October 12, 2016

Bayside Bowl Roof Deck Fire Pit

Please see the corresponding revised ASK-05 - 10.12.16.

ASK-05

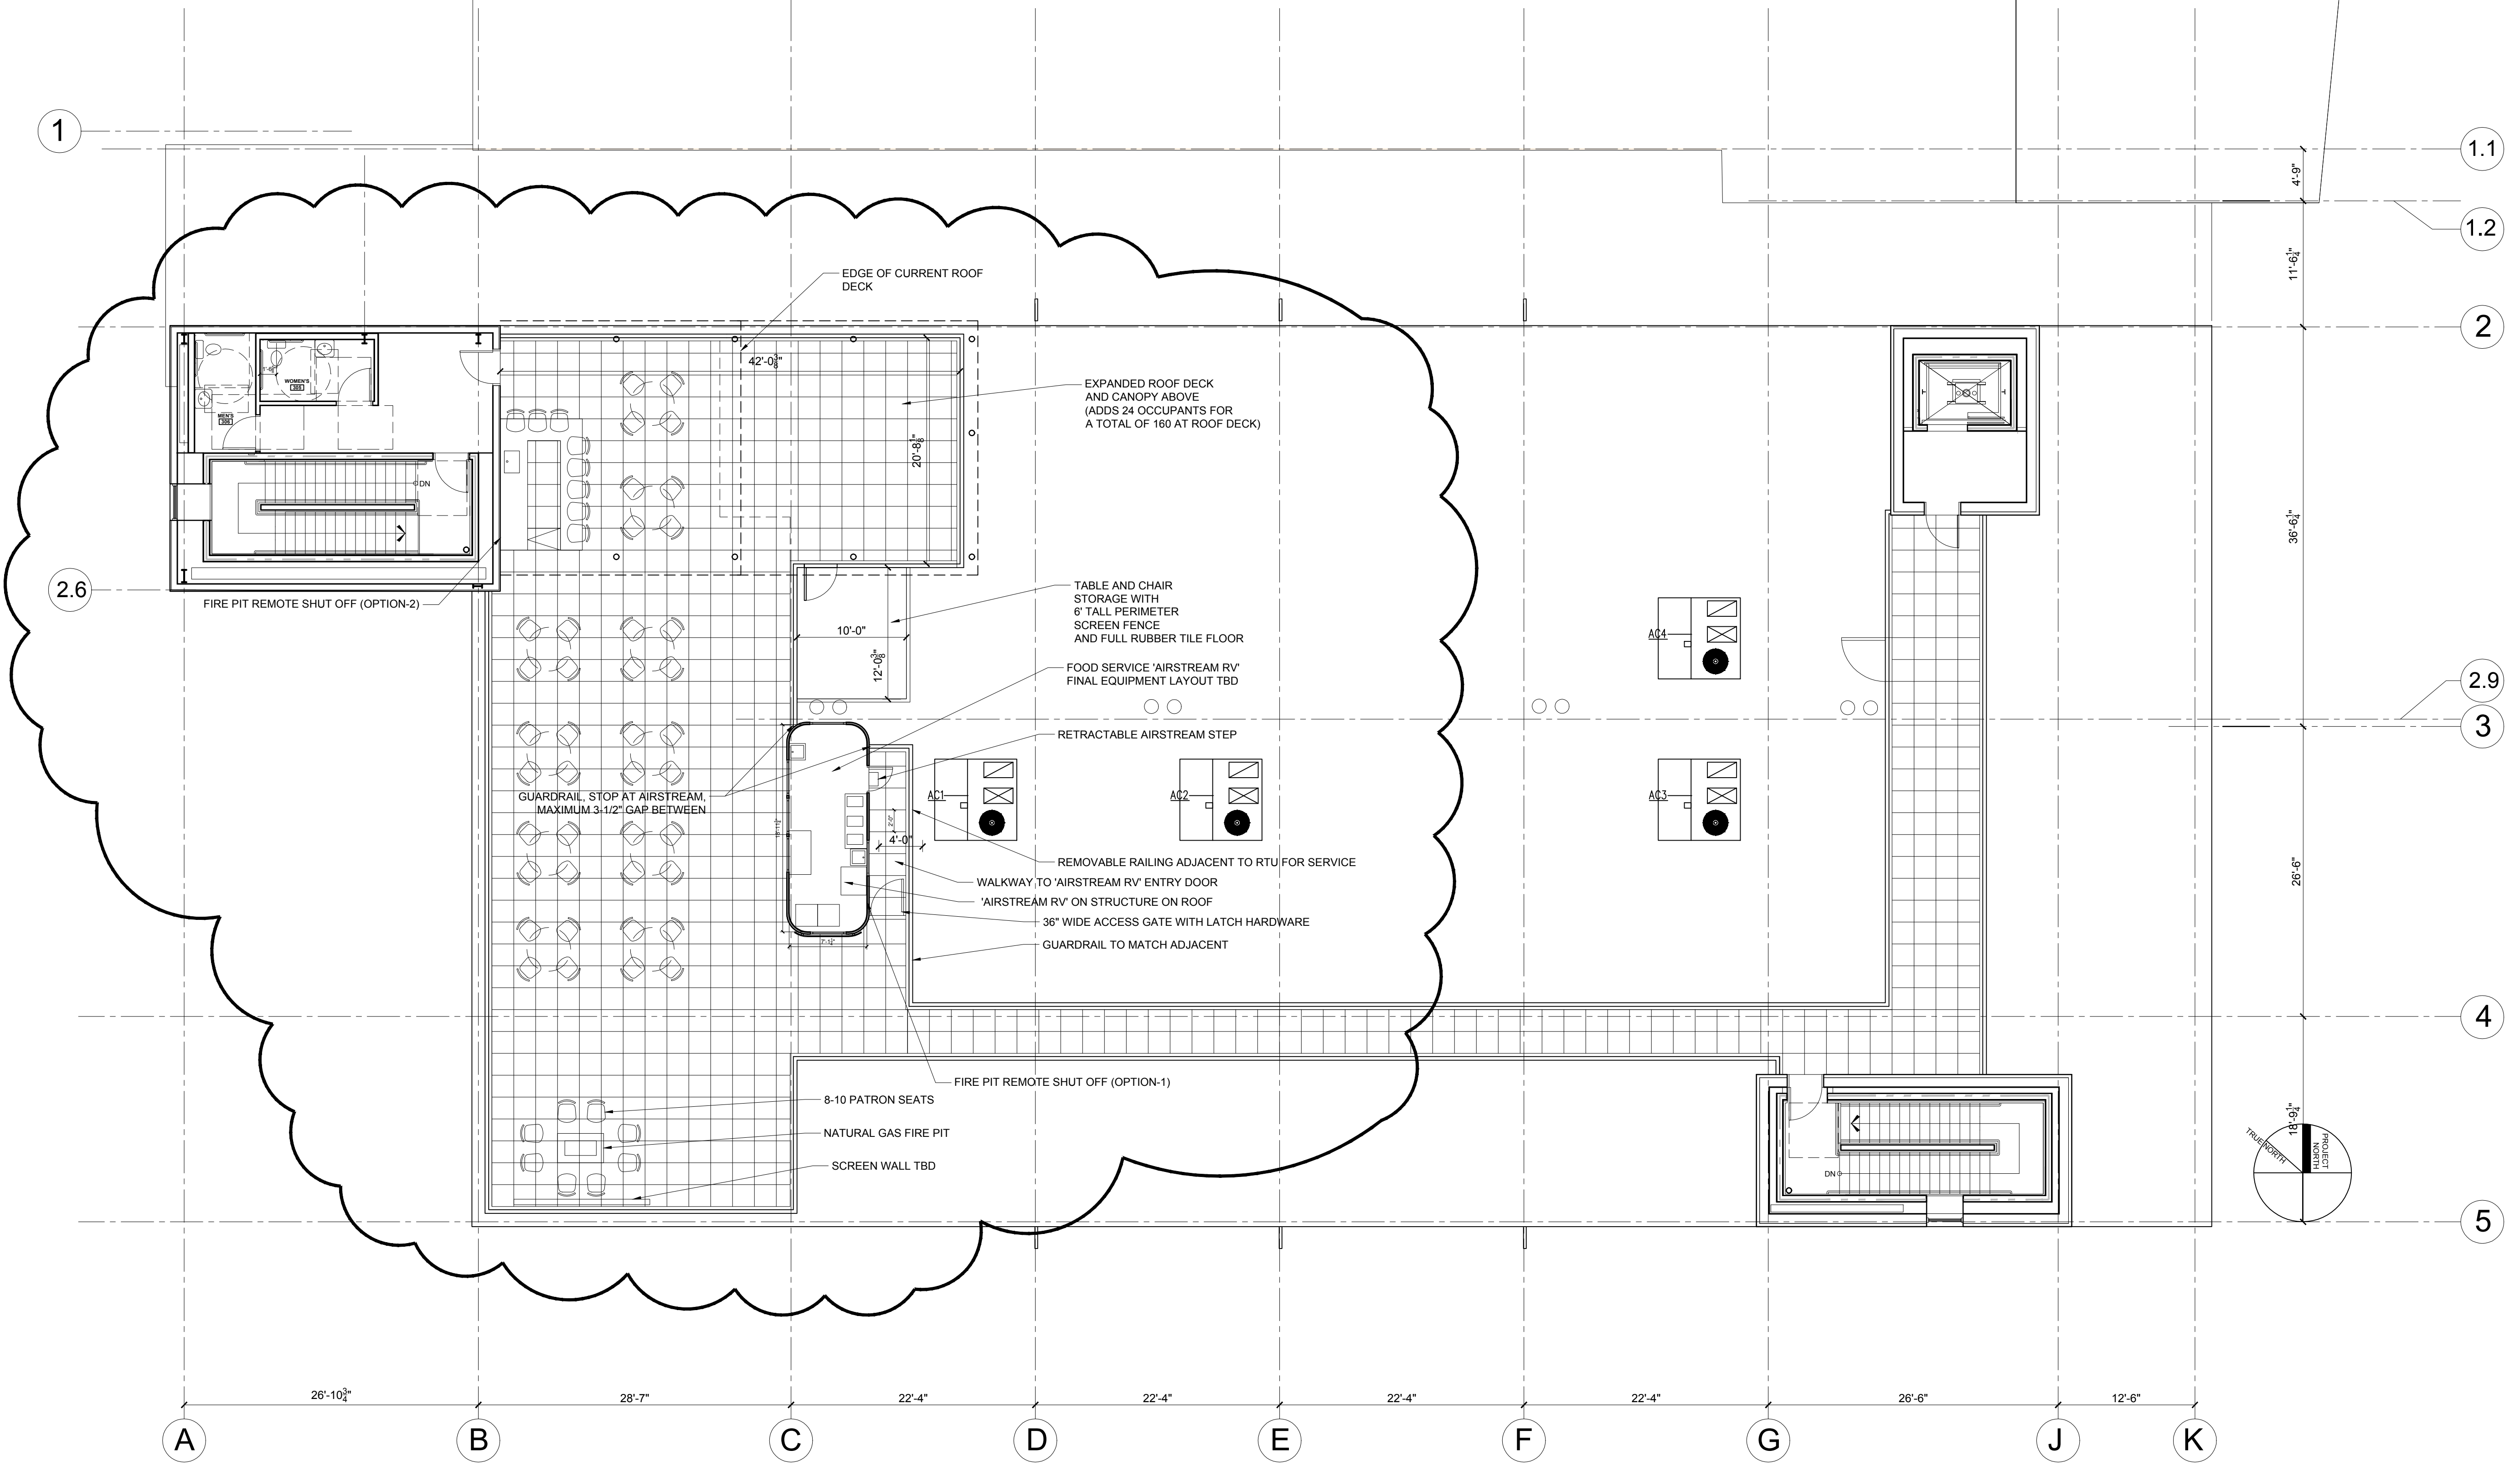
After a meeting with Assistant Fire Chief, Keith Gautreau, in which he approved our inquiry about adding a Natural Gas Fire-pit to the proposed roof deck at Bayside Bowl. Noting NFPA code 20.1.5.3 which states that no open flame device shall be permitted in a public assembly space. Except for the following.... (Sub_Section_4) If the device is intended for warmth than it shall be permitted and must be installed properly per 11.2 of the NFPA 1 Code. Which simply states that the device must be installed properly per manufacturer specifications and all applicable codes. As the building is already being outfitted for Natural gas this will simply be an extension of that code compliant system. AC Gautreau, asked that we install a remote shut off that would cut off supply to the fire pit in case of emergency. We will be locating this shut off either in the airstream or behind the bar.
